Department for Transport
By email to Planning Inspectorate

15 June 2022.

A47 North Tuddenham to Easton dualling scheme TR010038

Figure 4.18: AADTs in Scheme area – base and core scenario

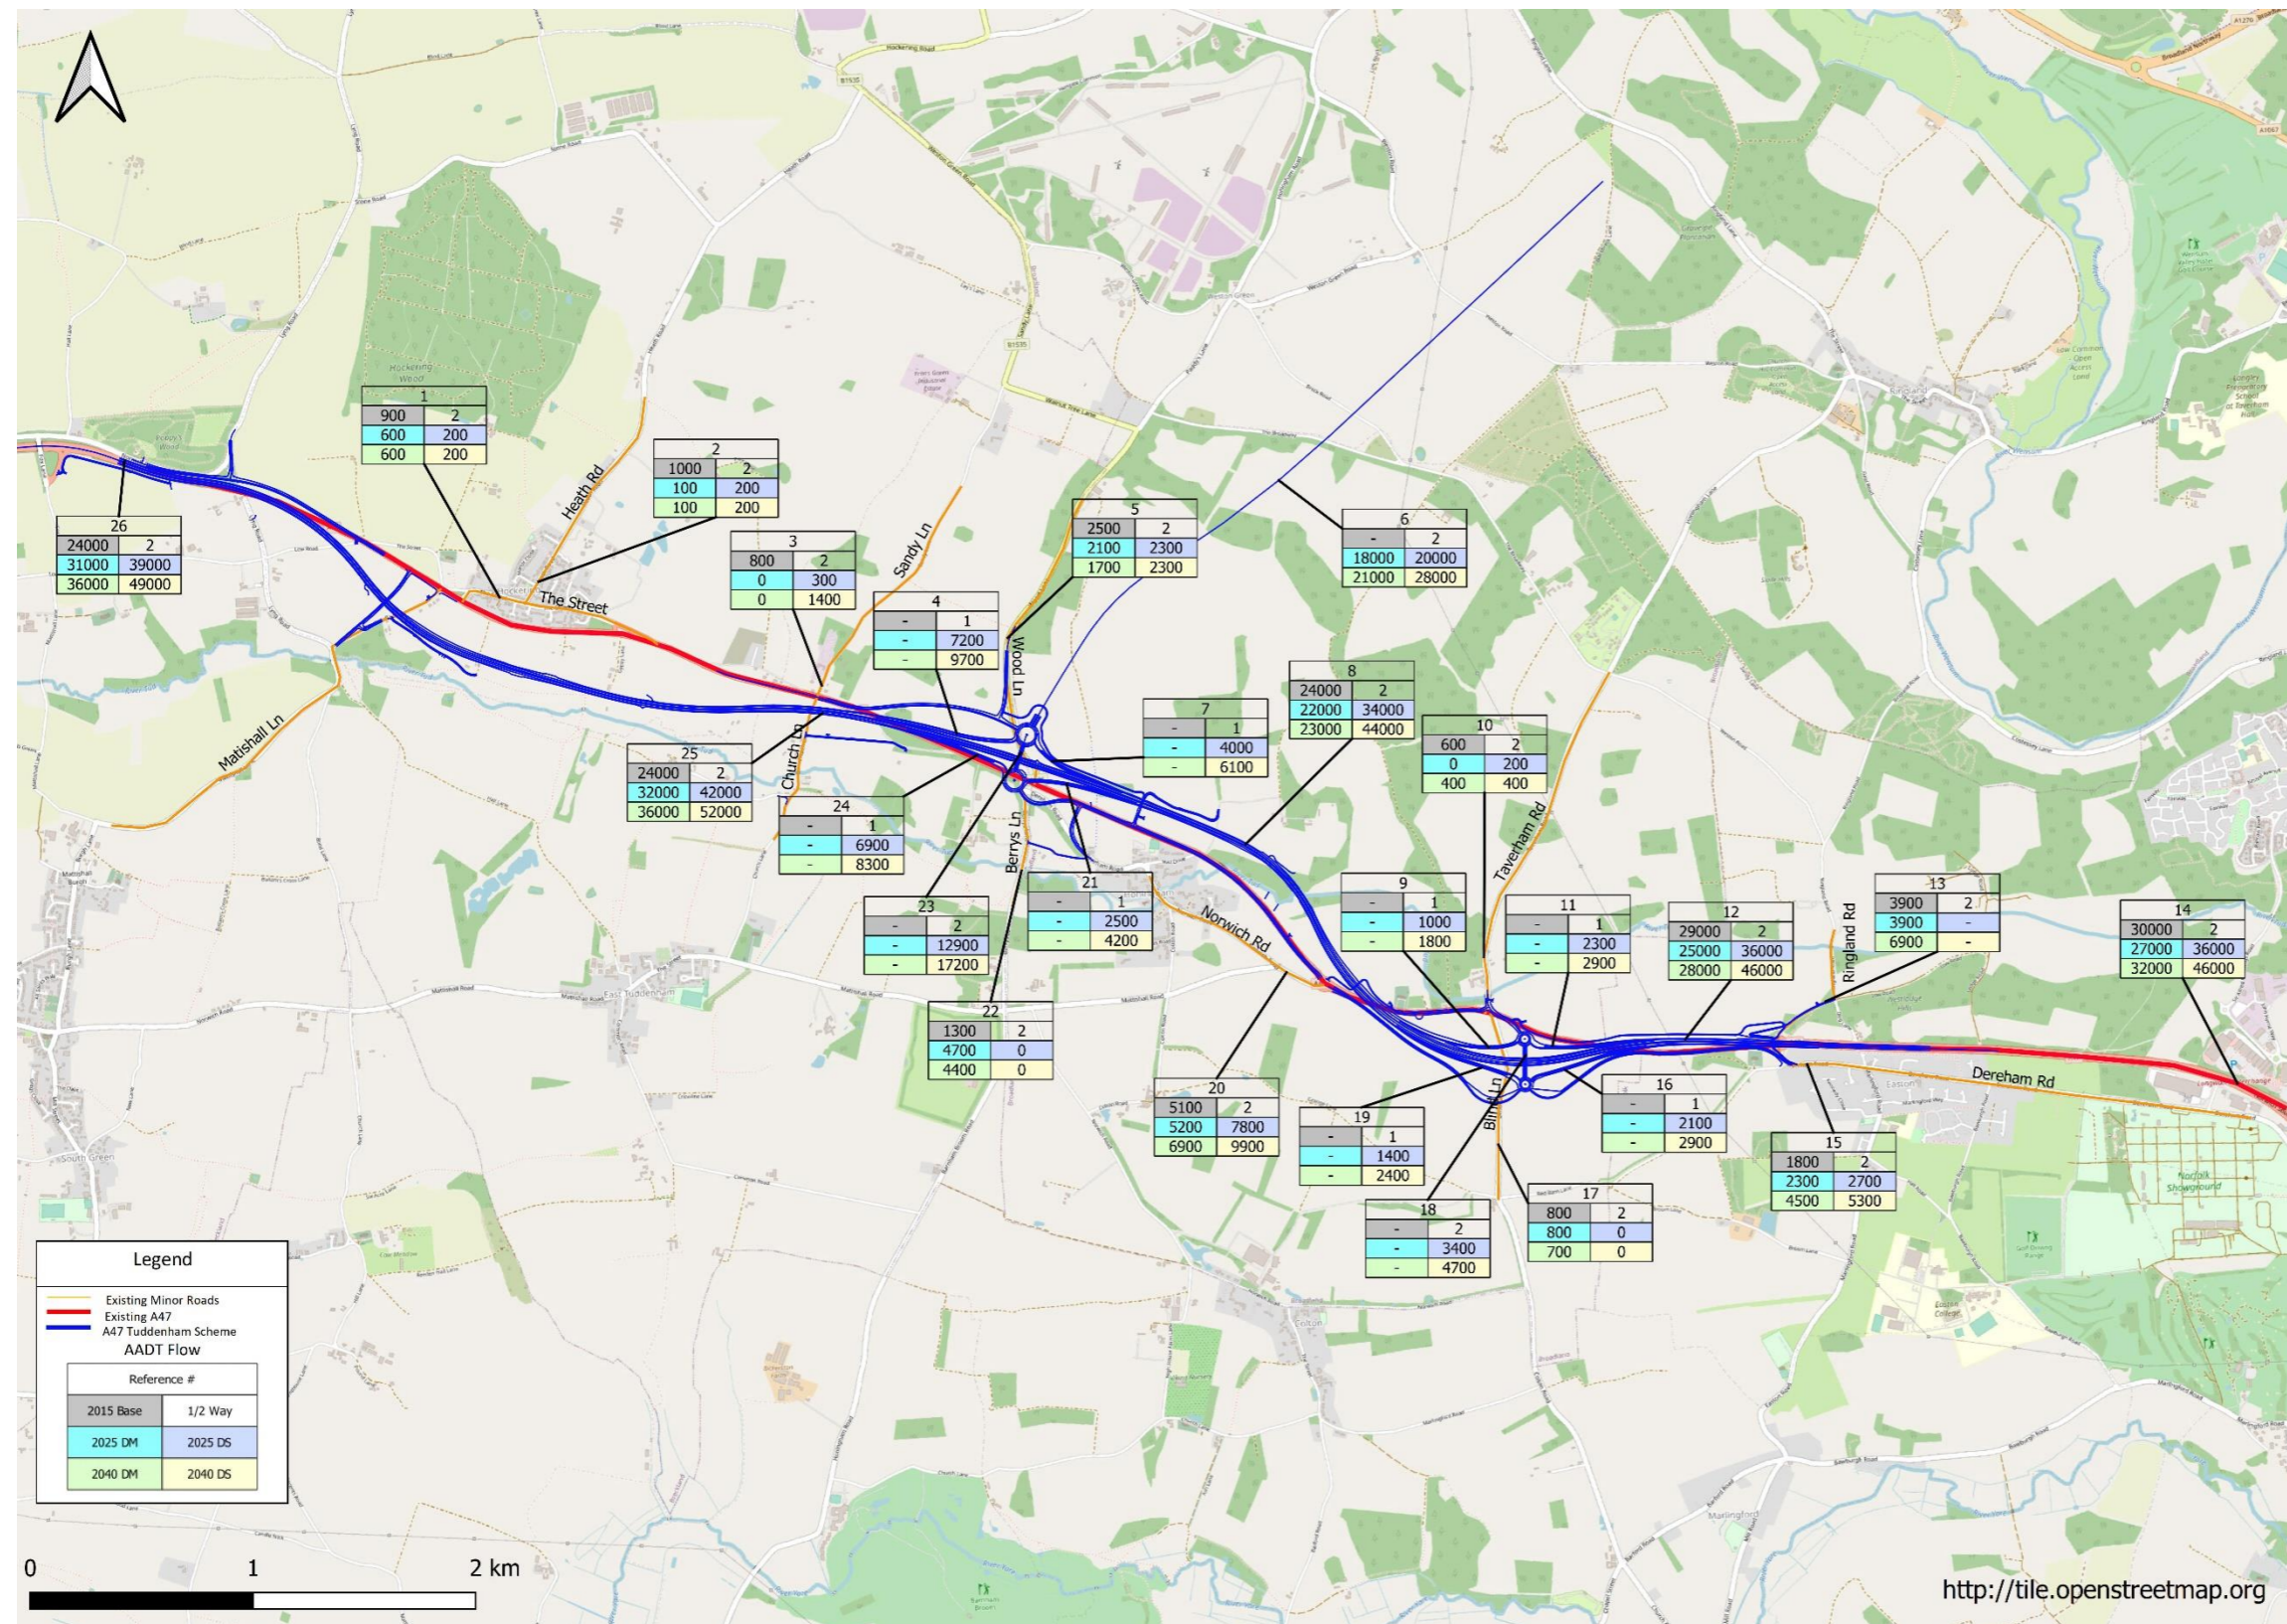
1. *The current situation.* Some daily traffic count figures given for the current situation (as of 2015) are not credible. The applicant has given no justification for:

- a) No difference in traffic flow on A47 between N Tuddenham (Fox Lane) and Wood Lane (B1535), yet there are several side roads. Without figures for those roads, it cannot be confirmed that traffic figures are unchanged over that stretch of A47. It seems very unlikely.

- b) No difference in traffic flow either side of B1535.
 - c) The flow on the Easton by-pass is only 1,000 more than just east of it. Yet we know around 4,500 use Church Lane, mainly to get on and off the by-pass, not to go west.

Figure 4.27: Core scenario DS (DS0) vs Without 'NWL' test DS (DS1) AADT flow diagram

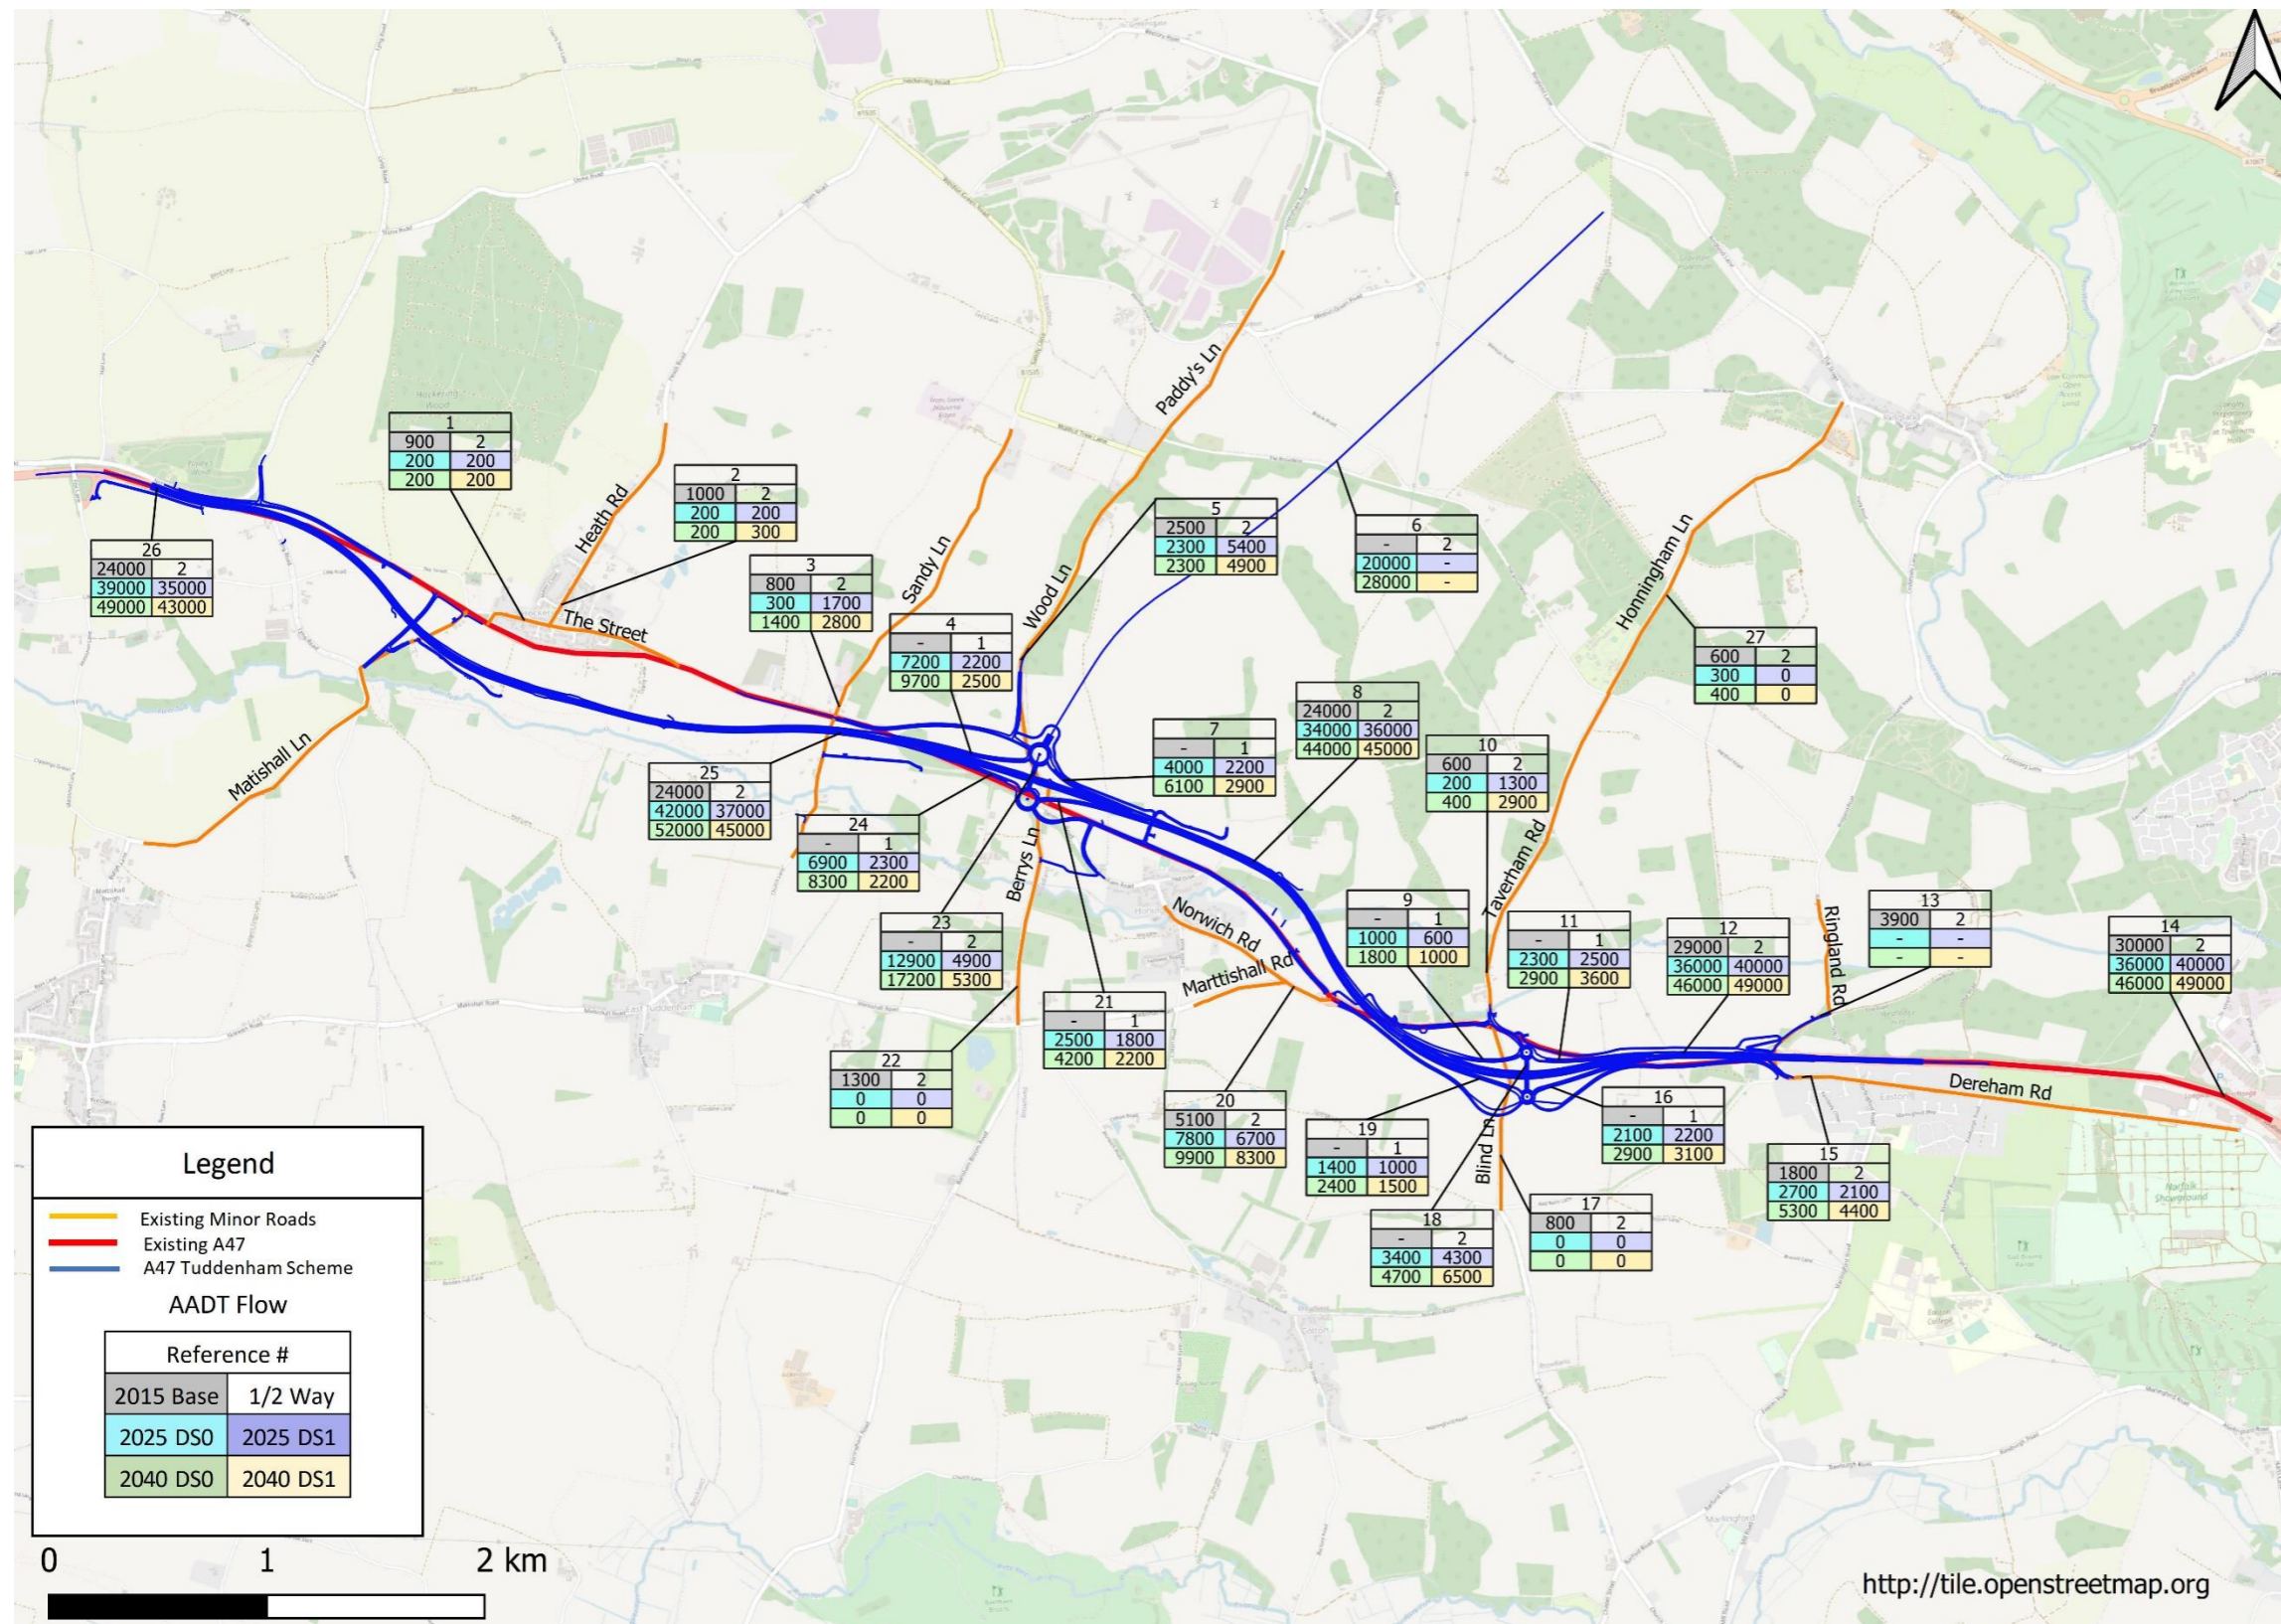
- a) Looking at the change from 2019 figures to those of DS1 (A47NTE but no NWL) in 2025; Wood Lane (B1535, two-lane with good connection to A47) takes no more traffic, but Sandy Lane (single-track of poor quality and no passing places and no direct connection to A47) takes 1400 more. The road through Hockering (C173, two-lane) takes 1400 fewer. This is against common sense.

- b) Looking at the change from 2015 figures to those of DS0 (A47NTE and NWL) in 2025:
 - i) the flow E of Hockering is 3,000 greater than flow W, yet there are no junctions.

- ii) there is a 53% increase in traffic on the rural Mattishall Rd. This runs roughly parallel with the A47; the dualled road is not doing its job if a result is that traffic increases on a parallel route.
